Engineers Comments Regarding Surface Water Drainage

Application Reference:	CM/6/24/DOC	Reviewer Reference:	ADC/EXT12/GK
Planning Officer:	Jessica Riches	Date of Review:	01.10.2024
Site Name:	Land to the West of Church Lane and South of Horsemere Green Lane Climping		
Application Description:	Approval of details reserved by condition imposed under CM/1/17/OUT relating to conditions 6-Phasing Plan and Programme , 8-Arboreal Method Statement, 9-surface water drainage scheme, 10-discharge of flows to watercourses or the culverting, diversion, infilling or obstruction of any watercourses on site , 11-Flood Management and Mitigation scheme, 12-Ecology Management and Mitigation Plan, 13-archaeological works, 14-Constuction Method Statement, 15-Travel Plan, 16-energy efficiency measures, 17-acoustic barrier, 21-Employment and Skills Plan and 22-provision of broadband.		
Assessment Number:	2 of 2

NoApplication Reference: CM/6/24/DOC	Initial Issue Date:
Site Name: Land to the West of Church Lane and South of Horsemere Green Lane Climping	Issue Date: 02/01/2024
	Reviewer Reference: ADC/EXT12/GK

(Maximum pipe size 450mm diameter)

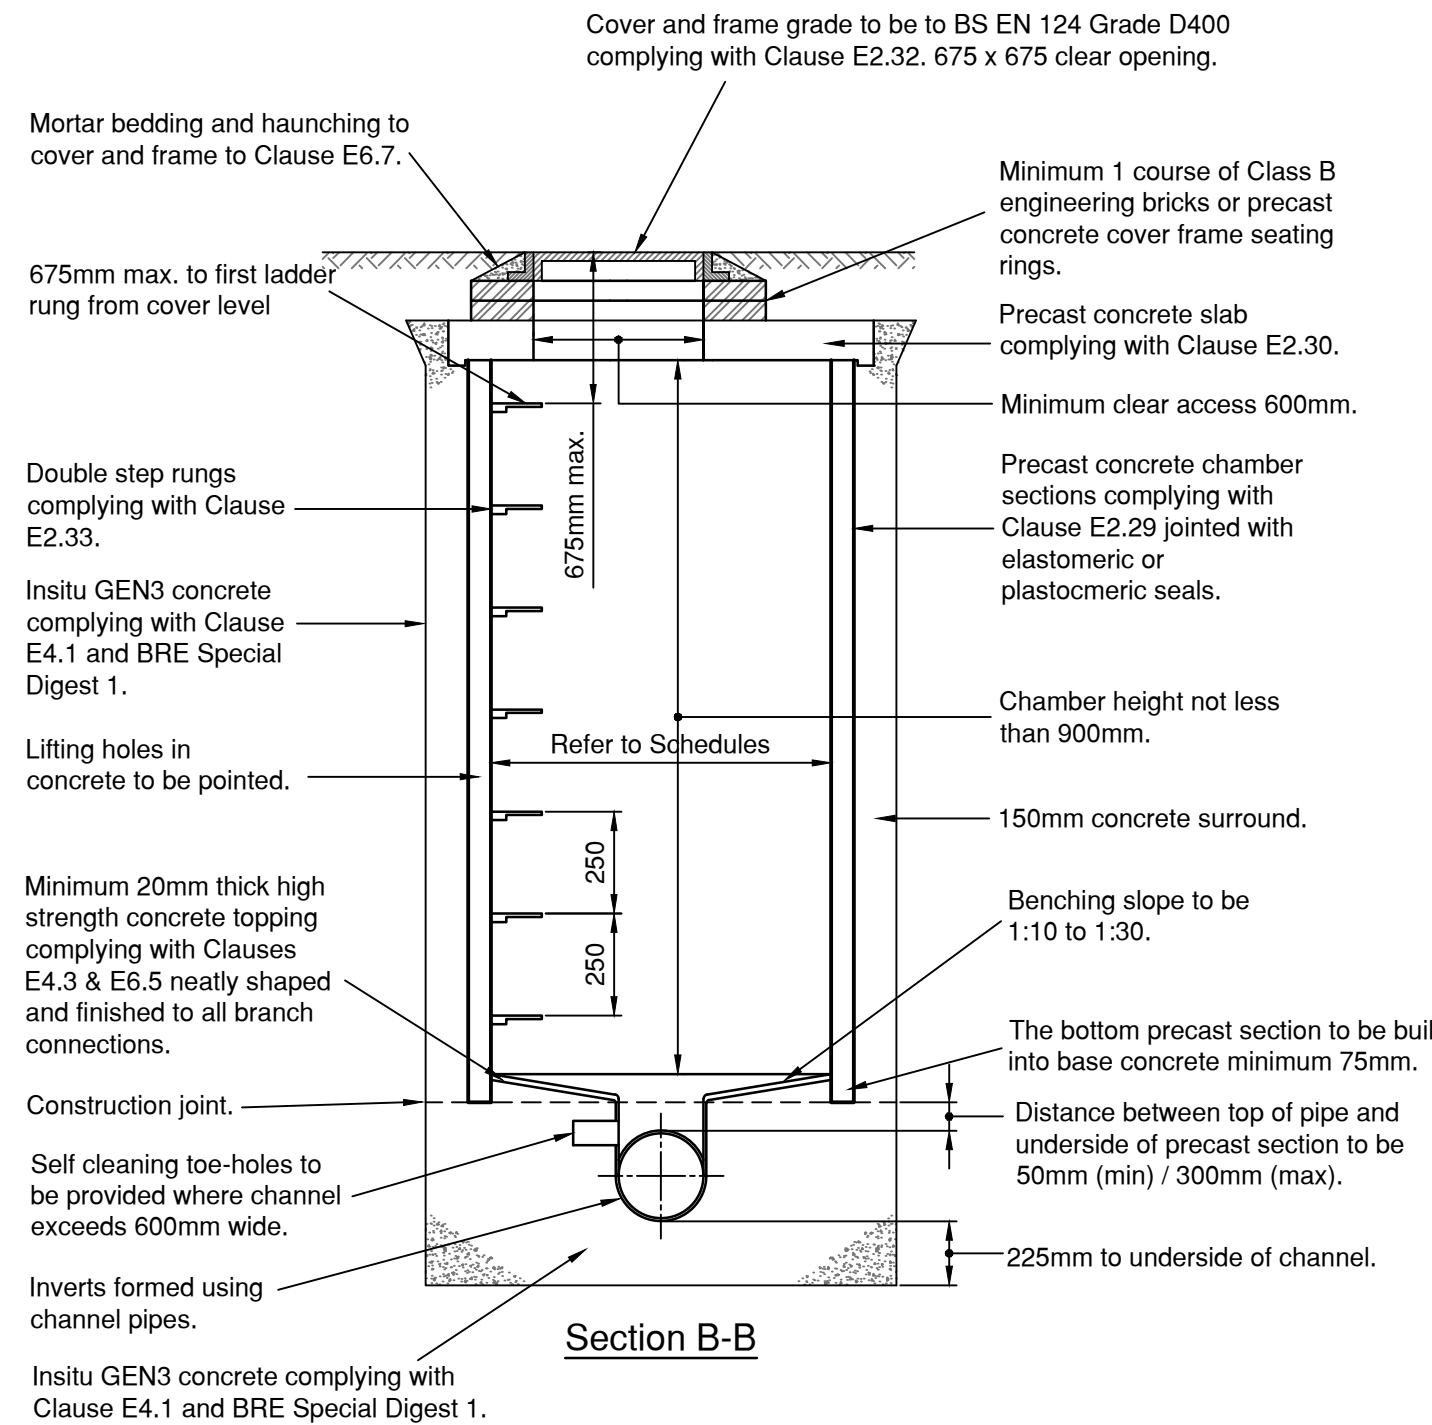
12.	No manhole schedules have been provided.	No comments – refer to updated design.	Manhole schedule submitted but many manholes are missing probably due to wrong printing options. All the manholes are shown as Type E which is impossible. Please also note which manholes are catchpits. All the manholes have a diameter of 450 which is wrong in many cases. Please amend. Please specify the cover type on manhole schedule. Clarify how the shallow pipes will be protected.	The schedules (domestics FOR-E5139-419 and mains FOR-E5139-415 to 418) give information on manholes. Information on all private drainage is not given as this is subject to change on-site during construction and to offer the groundworker a level of flexibility. These refer to the inspection chambers, manhole types have been removed for clarity (as they are not applicable) - FOR-E5139-419 These refer to the main inspection chambers for the private drainage. Refer to table on plan regarding cover types - FOR-E5139-415 to 418 Pipes shall be protected in accordance with pipe bedding details (FOR-E5139-474). Where minimum cover cannot be achieved, pipes shall be protected via a concrete slab.

Drawing Code	Drawing No.	Rev.
000-BPC-WD-ZZ-D-C	D474	-

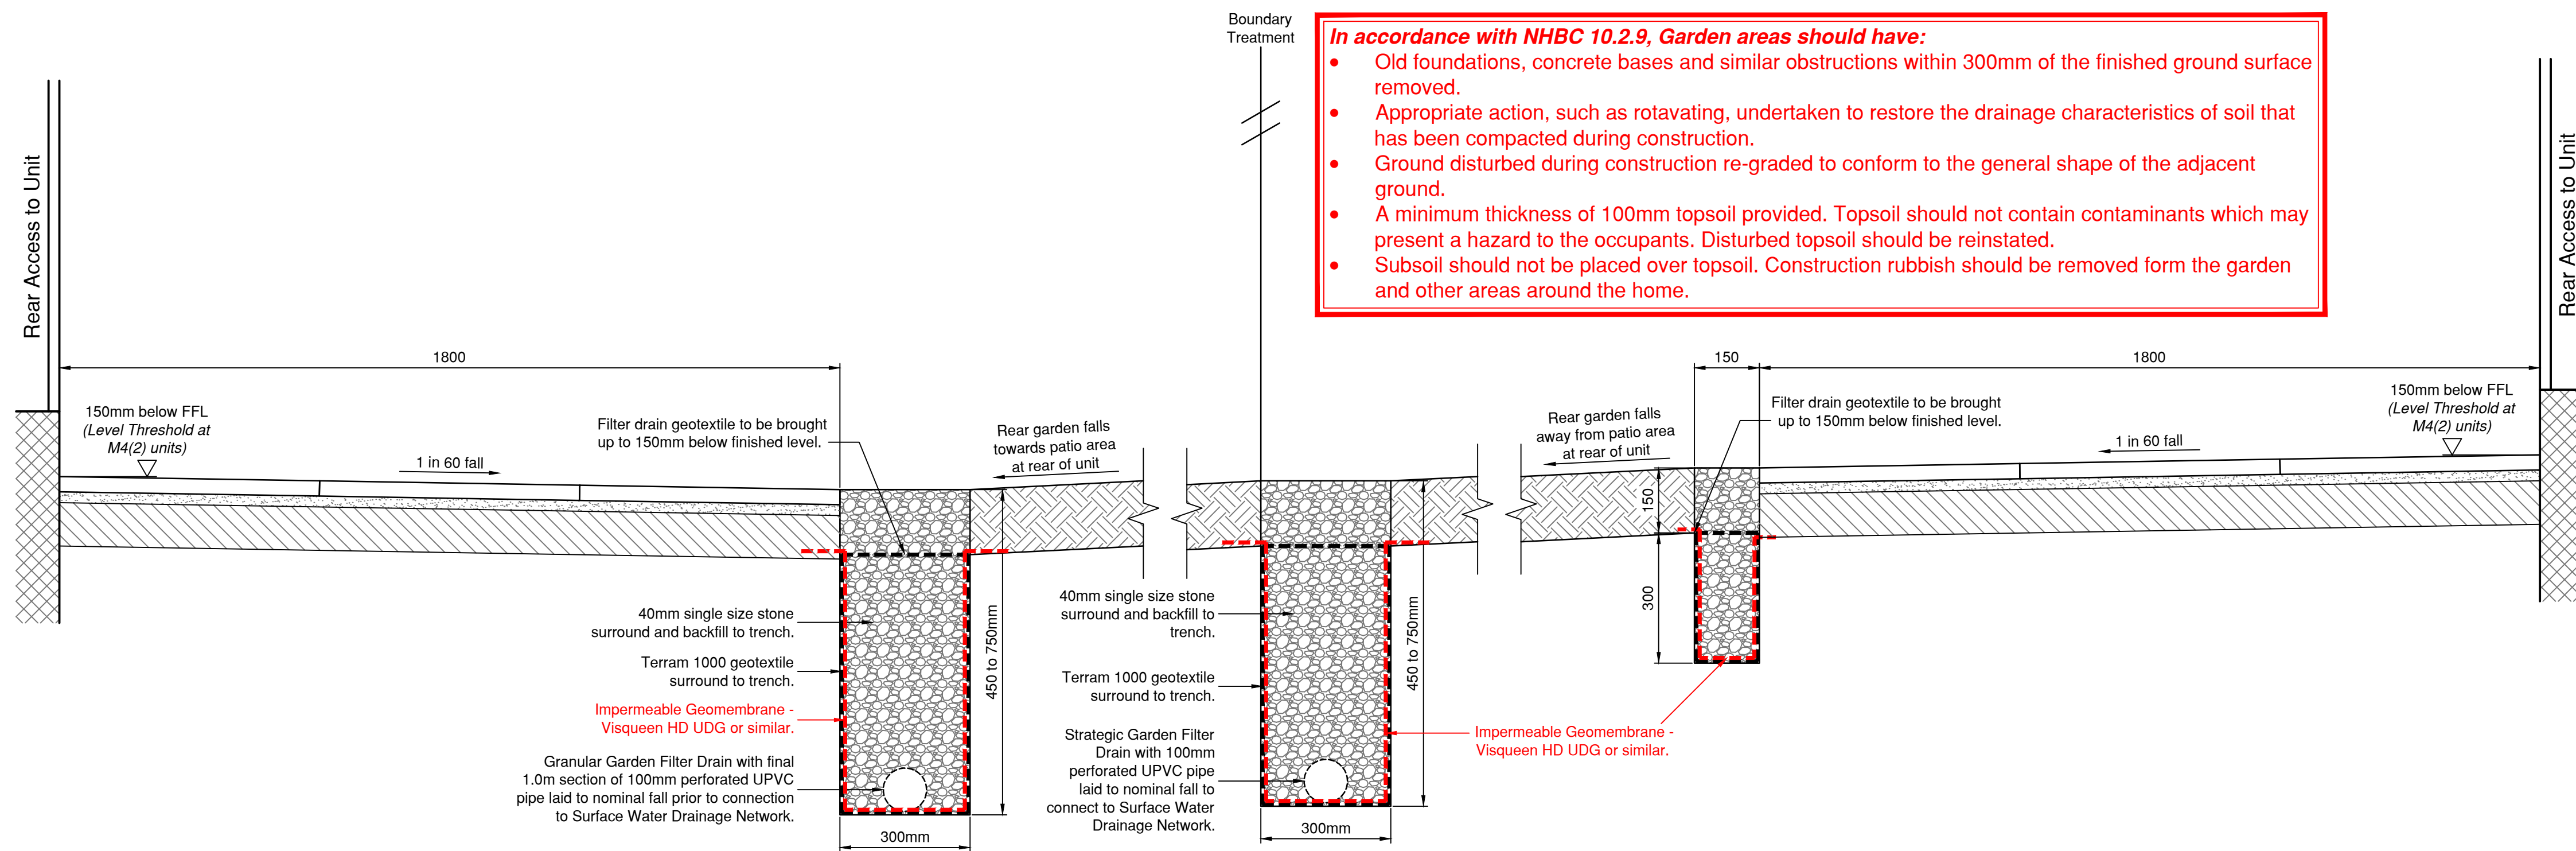
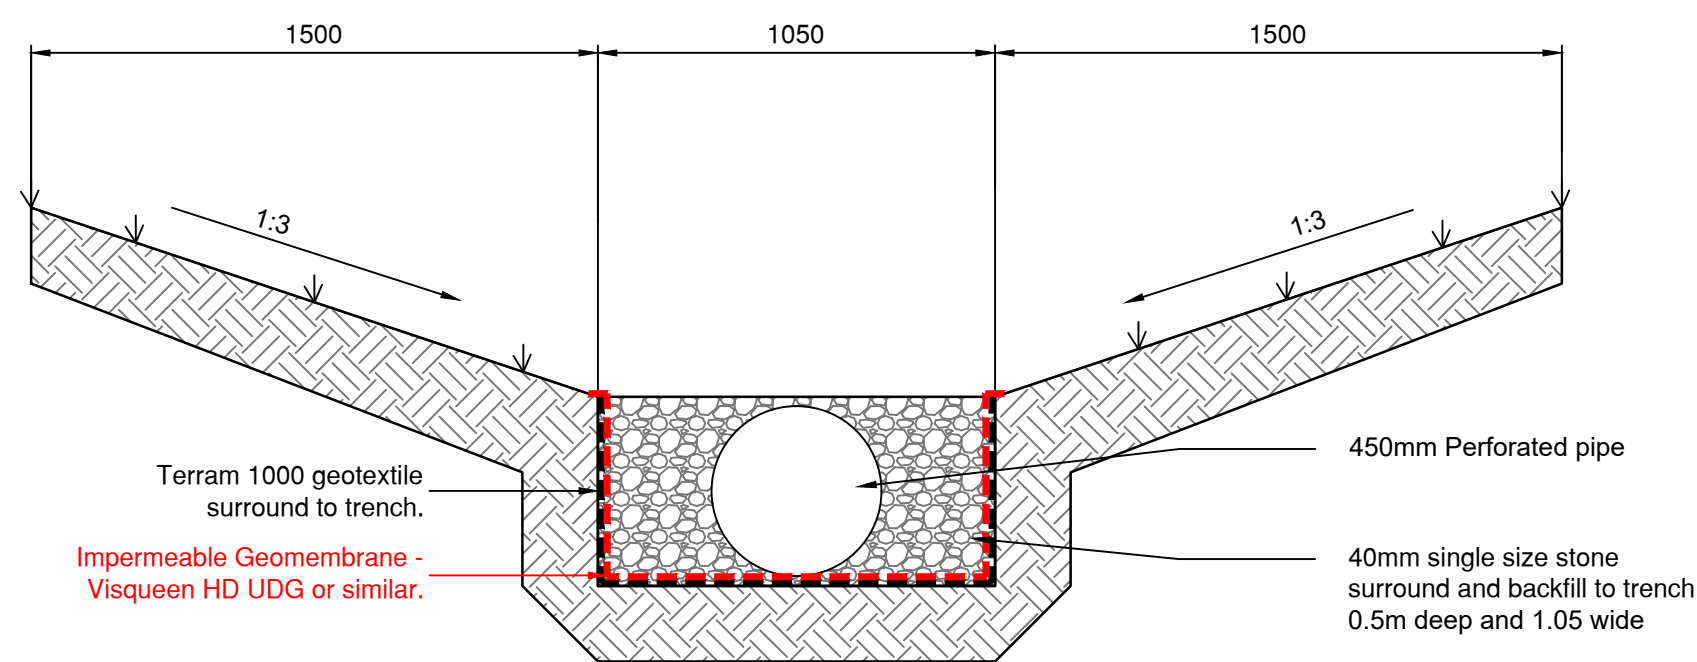
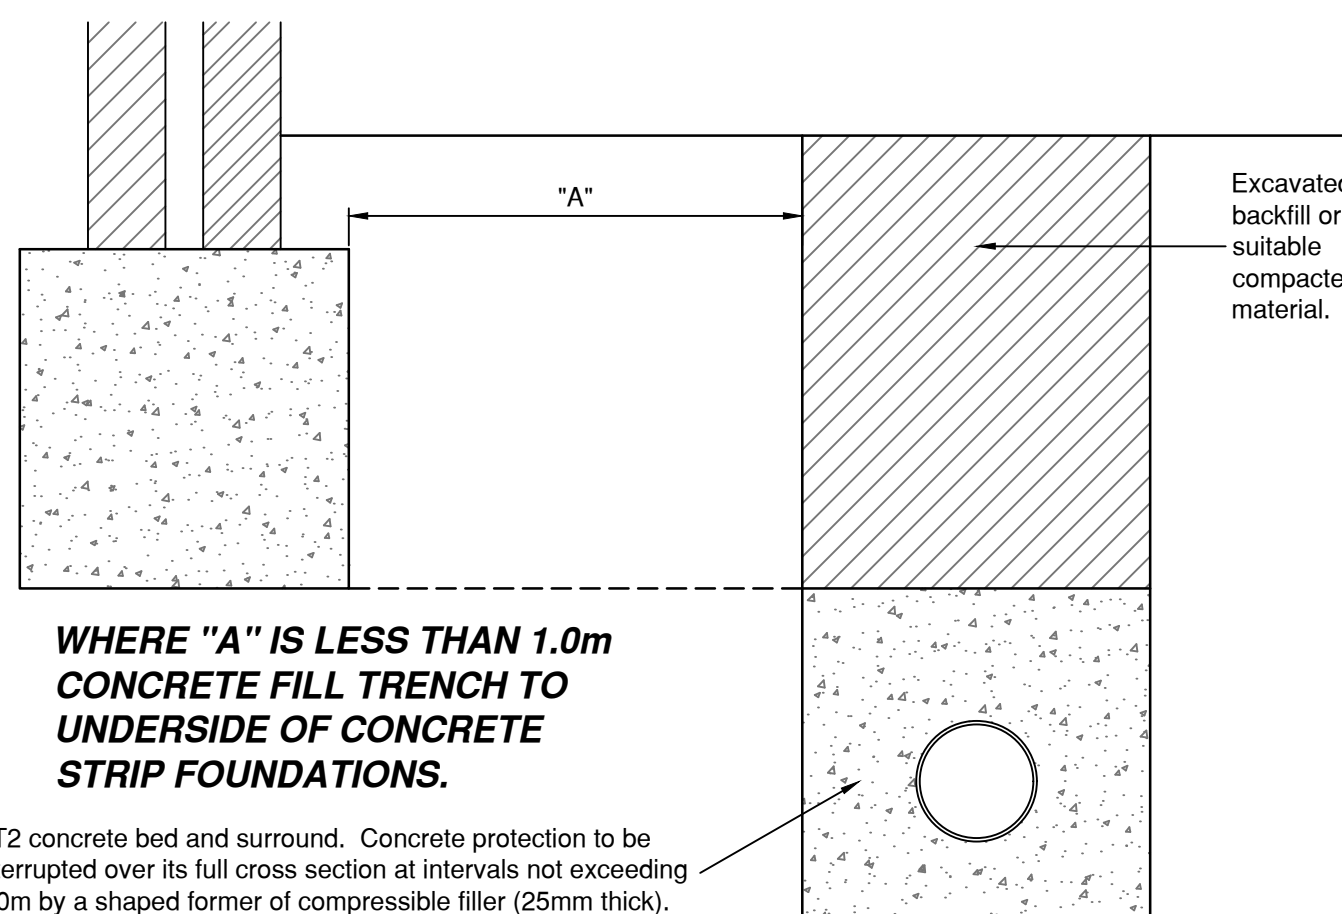
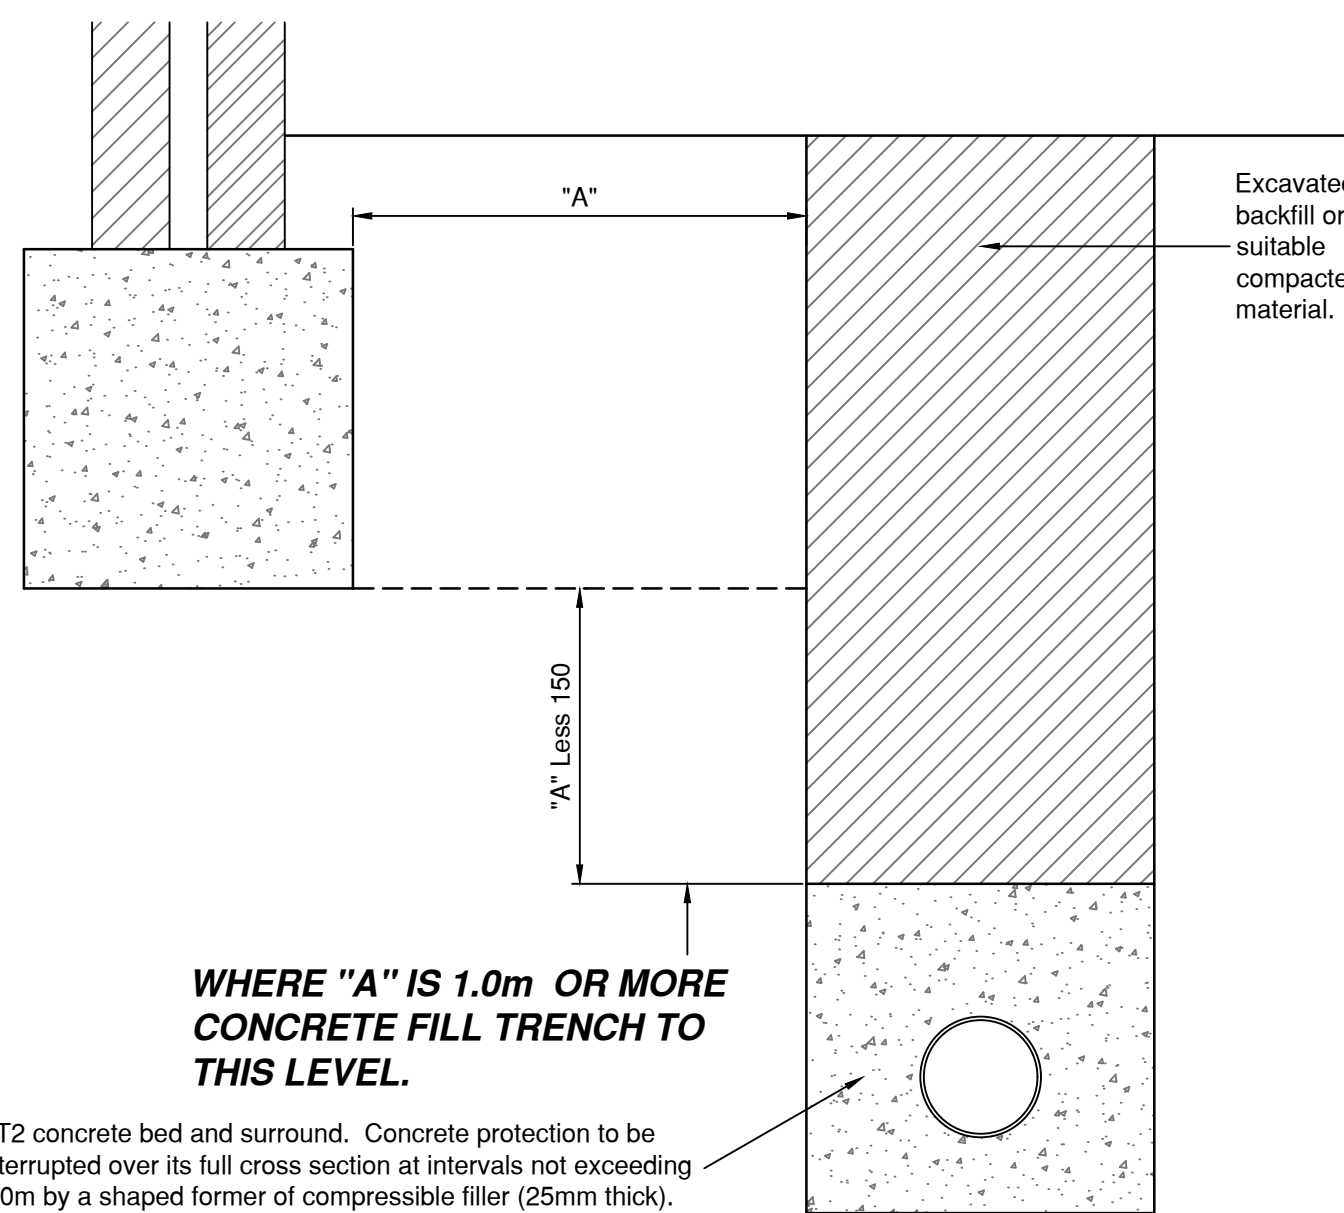
3.	Pipe materials are to be provided for all drainage runs, these are to be noted within the pipe label of each run on the drainage GA's.	No comments – refer to updated design.	Comment remains.	For mains drainage pipes up to 300mm will be vitrified clay. 300mm and over will be concrete (refer to FOR/E5139/410).
